## New Maitland Hospital Stage 2 SSI – Response to Submissions Agency Submissions

## Response to Public Submissions

Metford Clay Mine
FIGURE ONE:
Location and
Property Boundaries

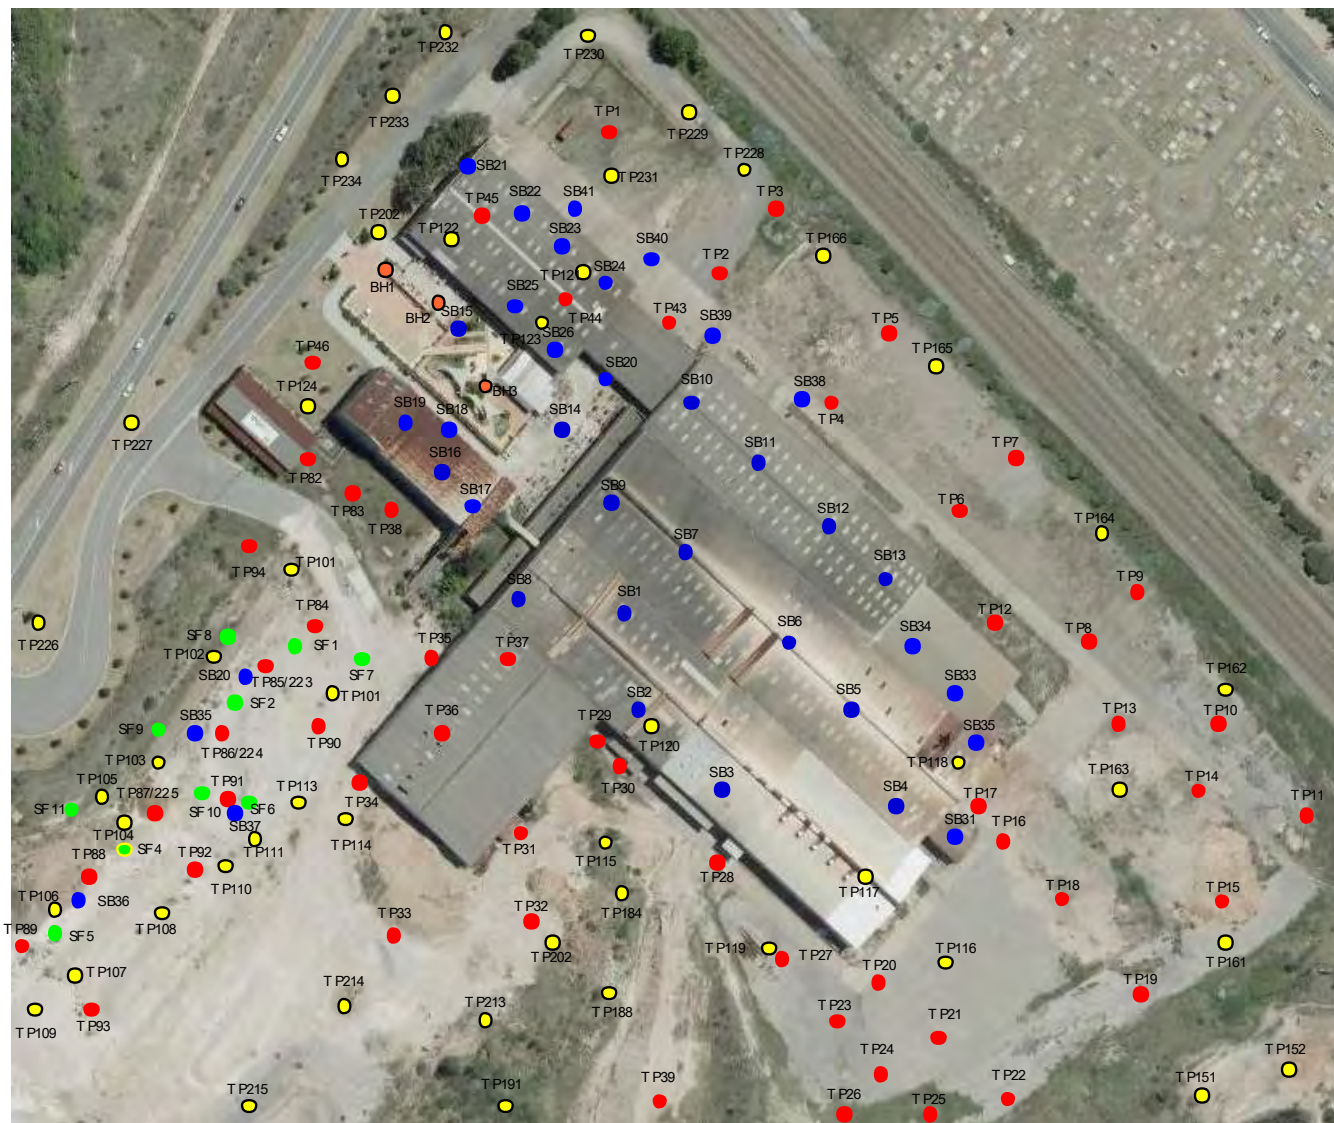
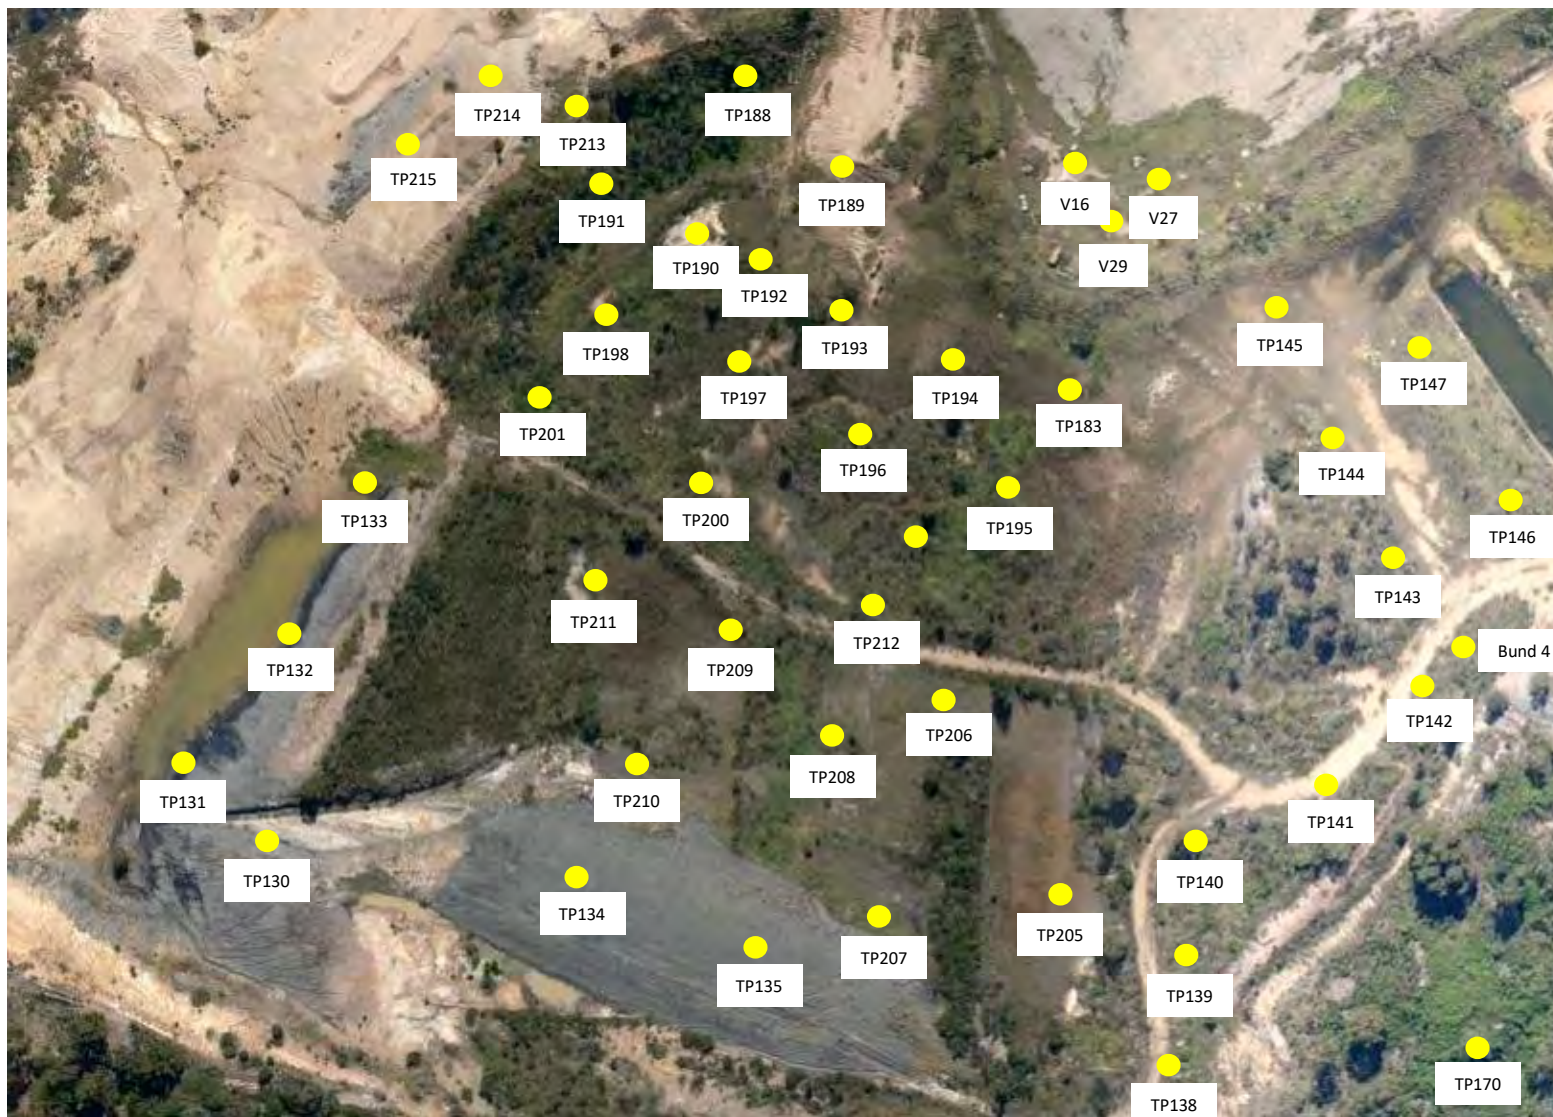
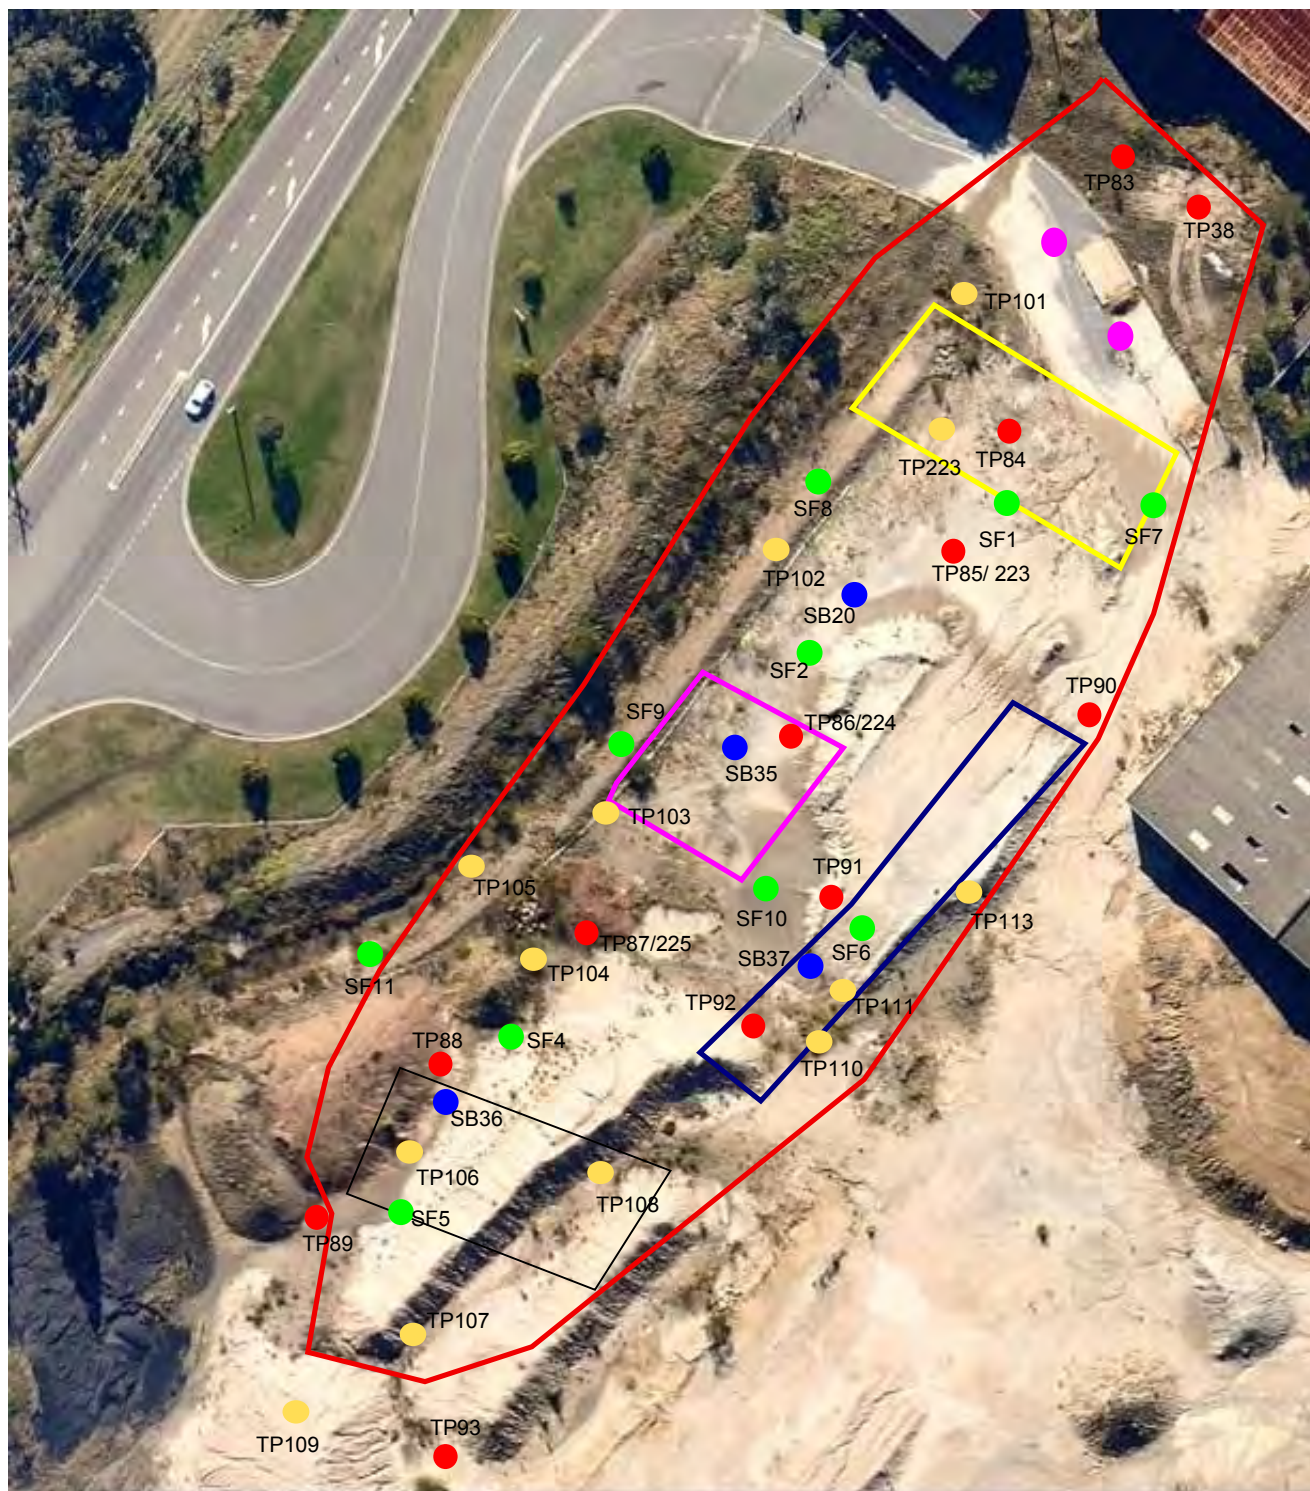
48	<p><b>2. Contamination</b></p> <p>Information contained in the EIS in relation to survey is limited to:</p> <ul style="list-style-type: none"> <li>• a site audit statement for Lot 7314 DP 1162607 (having an area of approximately 17 hectares) certifying that the site can be made suitable for the proposed use, if the site is remediated/managed in accordance with the RAP/CMP prepared by GHD Pty Ltd on 4 July 2016, to address the SEARs for Stage 1; and</li> <li>• a scope and methodology proposal for a detailed site investigation over Part Lot 401 DP 755237 (having an area of approximately 2 hectares) to address the SEARs for Stage 2.</li> </ul> <p>GHD previously carried out a detailed environment al site (contamination) assessment and remedial action plan (RAP) for Lot 7314 DP 1162607 only, to address the Stage 1 SEARs, based on the understanding that Part Lot 401 would be used by CSR for storage of contaminated material found during the development of Lot 7314 and that no development/remediation/construction works associated with the NMH would be undertaken within Part Lot 401. However, as part of the Stage 2 works, HI now</p>	<p>In accordance with Clause 5.22(2) of the EP&amp;A Act environmental planning instruments, including State Environmental Planning Policy 55 (SEPP 55) do not apply in respect of SSI. Notwithstanding, HI has undertaken an assessment of contamination that is consistent with the objectives of the SEPP 55.</p> <p>Additional information for Part Lot 401 has been prepared by GHD and JBS&amp;G and is included in the updated Contamination Plan at <b>Appendix E</b>. It now includes;</p> <ul style="list-style-type: none"> <li>• Site Investigation Report</li> <li>• Remediation Action Plan</li> <li>• Interim Site Audit advice</li> </ul> <p>Health Infrastructure will undertake further site investigations as set out in the RAP prior to the commencement of site preparation works on Part Lot 401 as requested in the EPA submission ahead of preparing a Site Audit Statement and Site Audit Report by the Site Auditor (JBS&amp;G).</p>

Item	Issue	Response
	<p>proposes to construct a carpark on Part Lot 401, which will likely require excavation and/or movement of existing stockpiled materials. Accordingly, in order to demonstrate that the site is (or can be made) suitable for the proposed use in accordance with SEPP 55, a detailed site investigation of Lot 401 will be required.</p> <p>In this regard, Council submits that the information submitted with the Stage 2 EIS in relation to contamination is inadequate. A detailed site investigation of Part Lot 401 should be carried out to assess and quantify any soil and groundwater contamination and demonstrate that the site is suitable for the proposed use in accordance with SEPP 55. The report should be submitted to OPIE and form part of the SSI application, to be properly assessed prior to any approval being granted.</p>	<p>We note that GHD have also confirmed that no materials have been relocated or stockpiled on Part Lot 401 as part of the Stage 1 works.</p>
